I represent Laxton and Moorhouse Solar Concerns, a group of individuals from our locale that is affected by part of the proposed solar array.

GNR Solar Park size is significant, causing different and common problems across a wide area and 20 parishes, and there is much I could discuss and argue, but have assumed that you will want me to focus on the issues that are particular to L&M.

Figure 8: PEIR to Environmental Statements

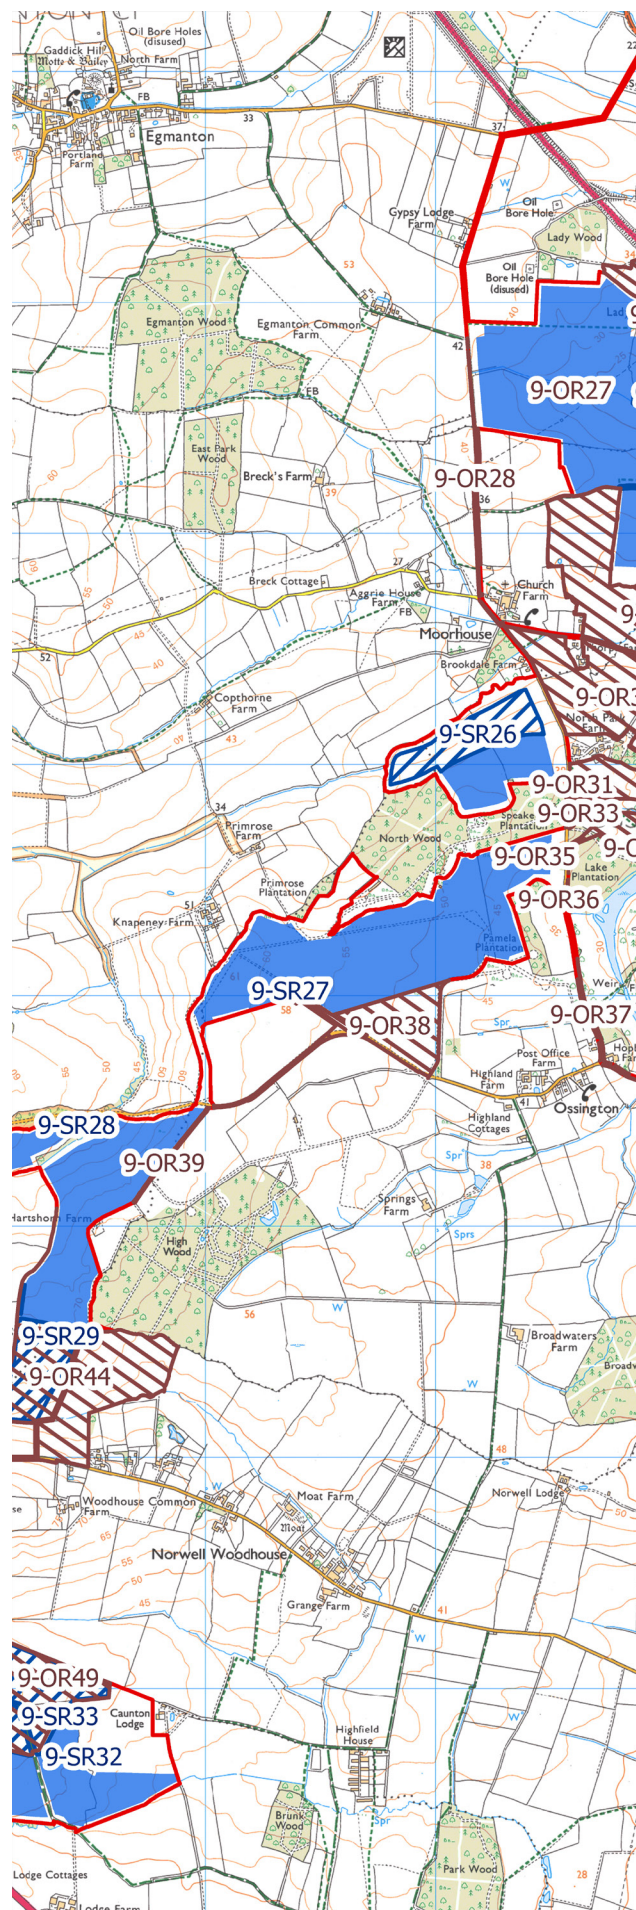
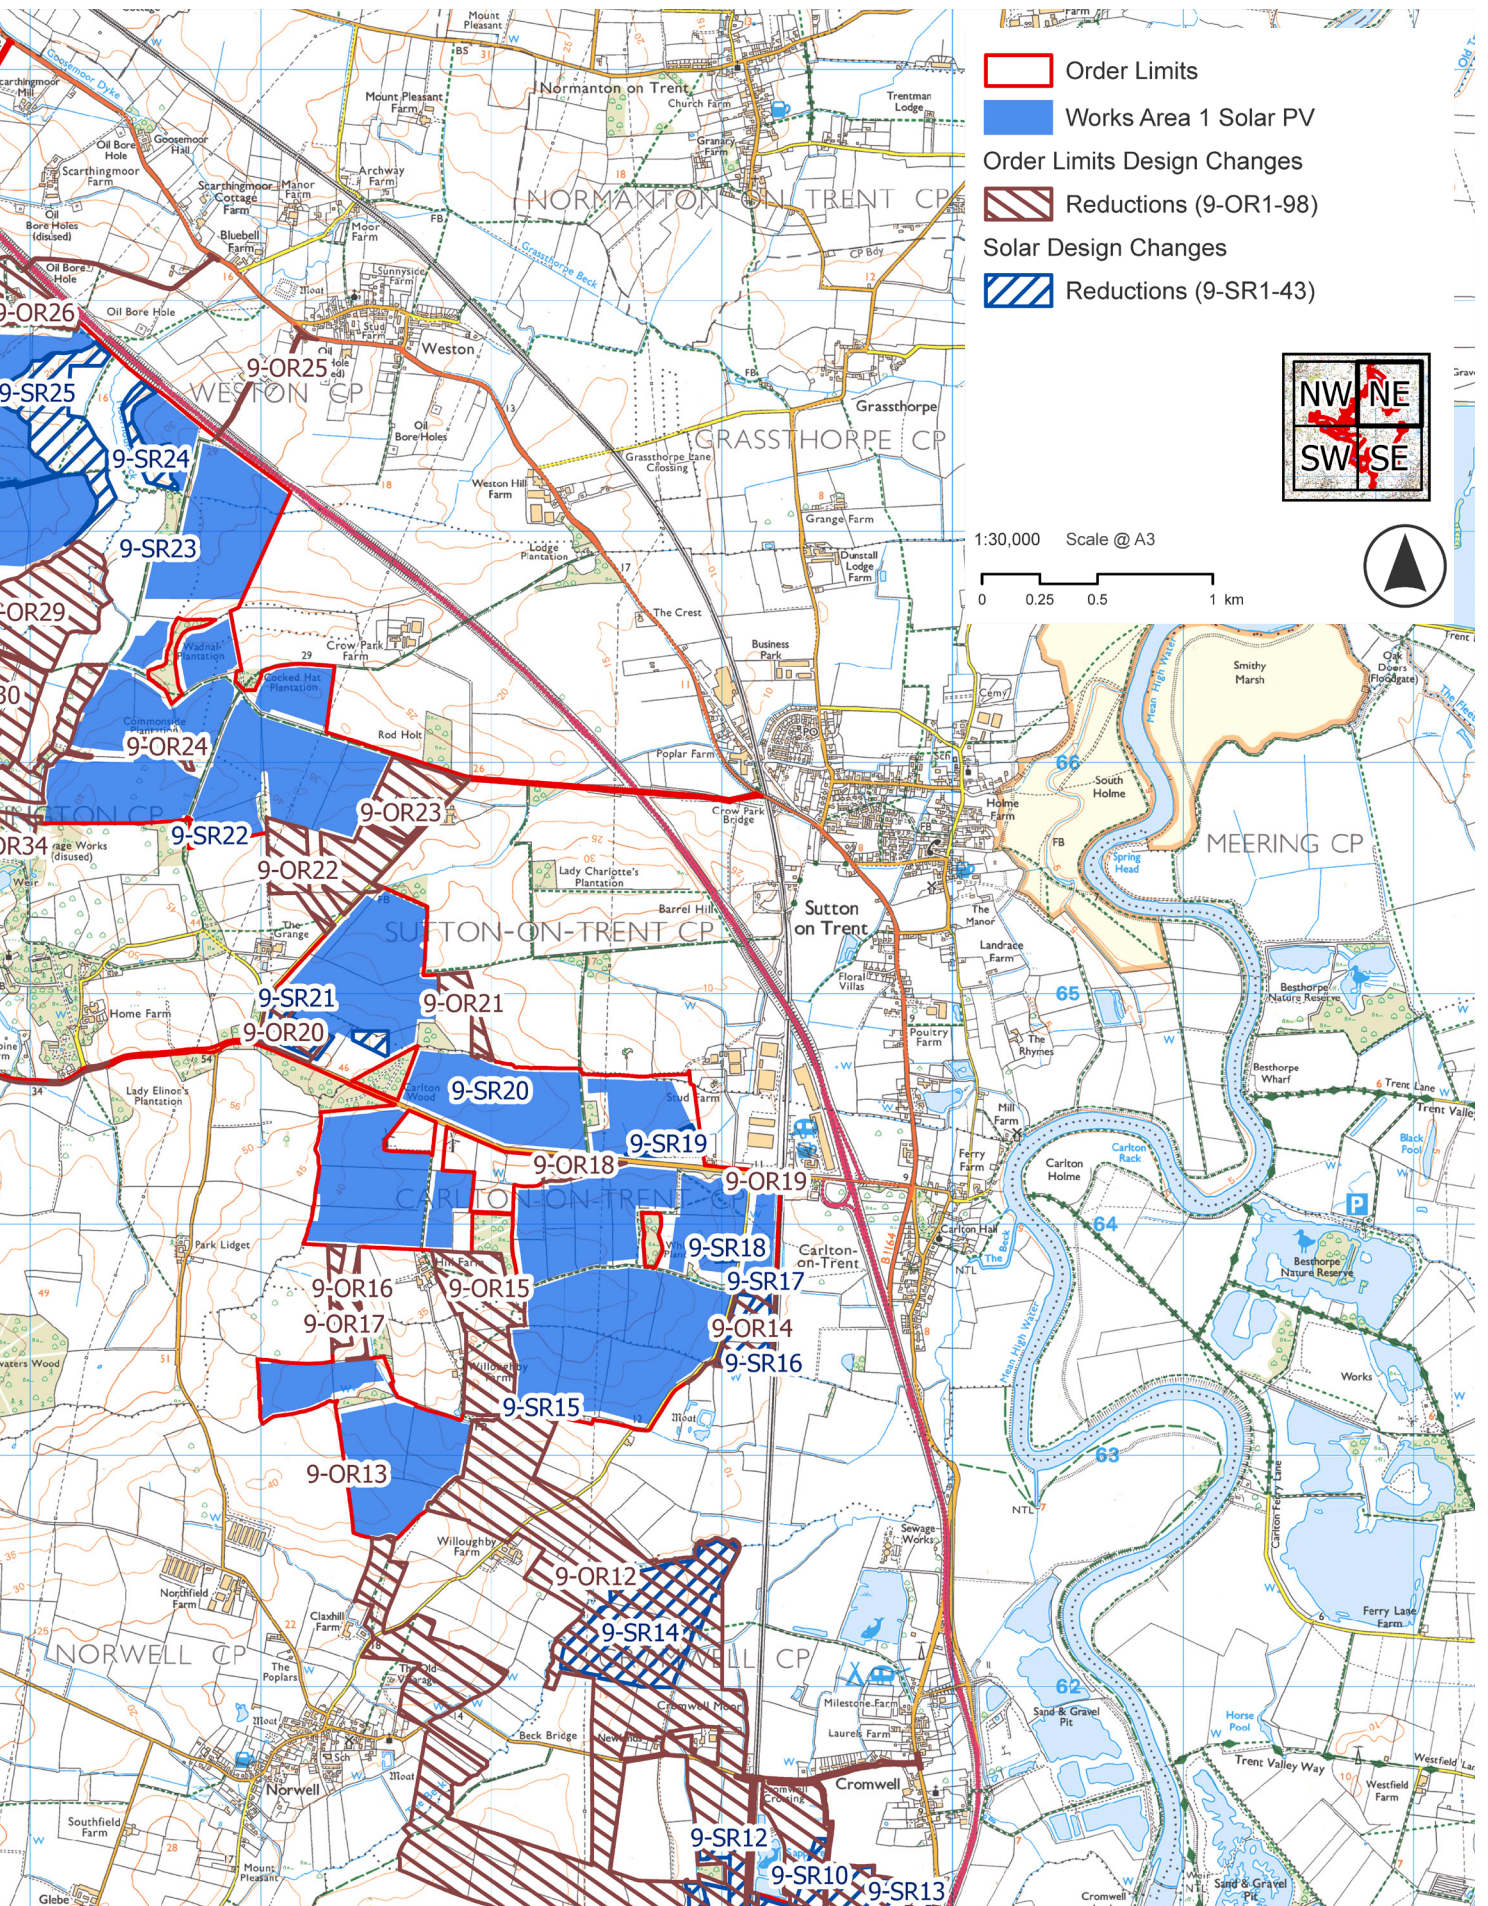
The issues lie primarily with flow down the main beck; flooding is usually short lived once the water escapes to the Trent. Unfortunately, the fields adjacent to the beck downstream of the village are all earmarked for solar panel arrays. (Fields N1 – N7).

Thus the concern is that at periods of heavy rain, the flow of water from Moorhouse area will be directly impeded by the increased rapidity of flow into the outflow from the solar panel fields which will rapidly overcome the beck's downstream capacity, backing up into the village.

This was raised with Elements Green, who disagreed with the contentions, but in their final submission, had reduced the solar panelling adjacent to the outflowing beck and replaced it with riparian land.

A cynic might suggest that EG have removed their panels from the likely flood areas, as they have done around Muskham, but the replacement with riparian planting will again impede waterflow and exacerbate the flooding problem for the villages.
